The Sizewell C Project

**Natural England's Response to Examiner's Questions Part 2**

Planning Inspectorate Reference: EN010012

3<sup>rd</sup> September 2021

A SECTION
SCALE 1:500

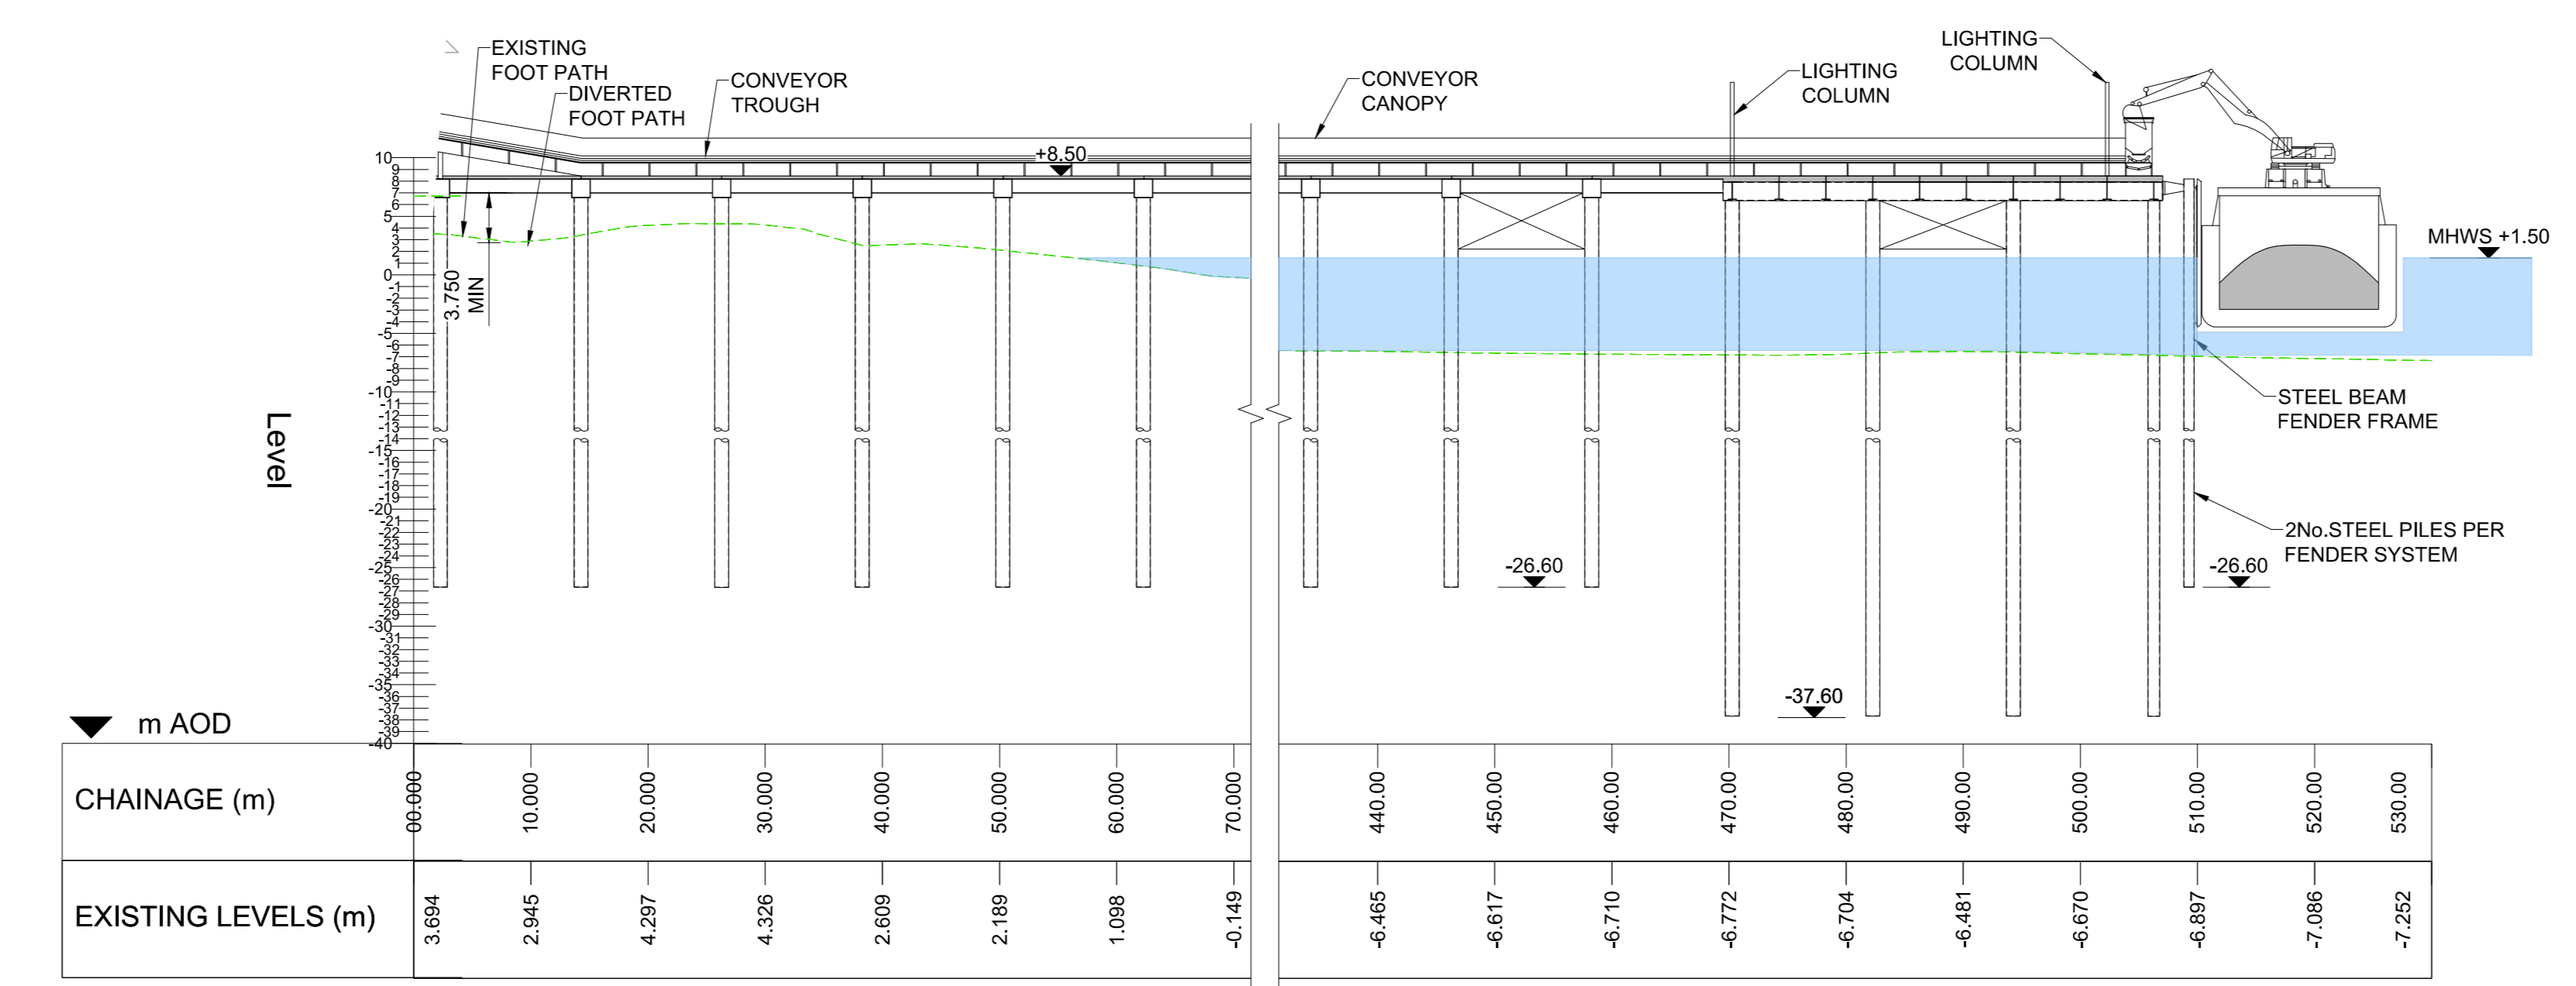
Sizewell C, TASC		<p>However, Natural England still welcomes the optimisation of the hybrid bridge-culvert SSSI crossing design to lessen its impact on invertebrates by raising the soffit height should this design be considered justified by the ExA.</p> <p>As outlined in our relevant representations [RR-0878] <i>“The main mitigation measure if a causeway is constructed is an effective planting scheme on and in proximity to the crossing to maximise how the causeway is screened and blended into the landscape. We note a commitment to plant the margins with trees and shrubs to integrate the crossing into the local landscape and screen / filter views of moving vehicles. That will not compensate for any significant harm which arises to the SSSI, but it may reduce the visual impact of the causeway and its cumulative impact with any visual degradation of the wetland habitat.”</i></p>
LI.2.9	The Applicant, ESC, Natural England, The AONB Partnership, Stop Sizewell C, TASC	Alternative Outage Car Park Note Please review and comment on the content of the SCC submission [REP5-171].	SCC makes a very clear and compelling case for an alternative solution. We support their contention that the proposal for additional outage parking to be sited within the designated landscape of AONB is disproportionate to the anticipated or likely need. This is particularly the case given that SCC have proposed alternative approaches which appear to be both practical and deliverable.
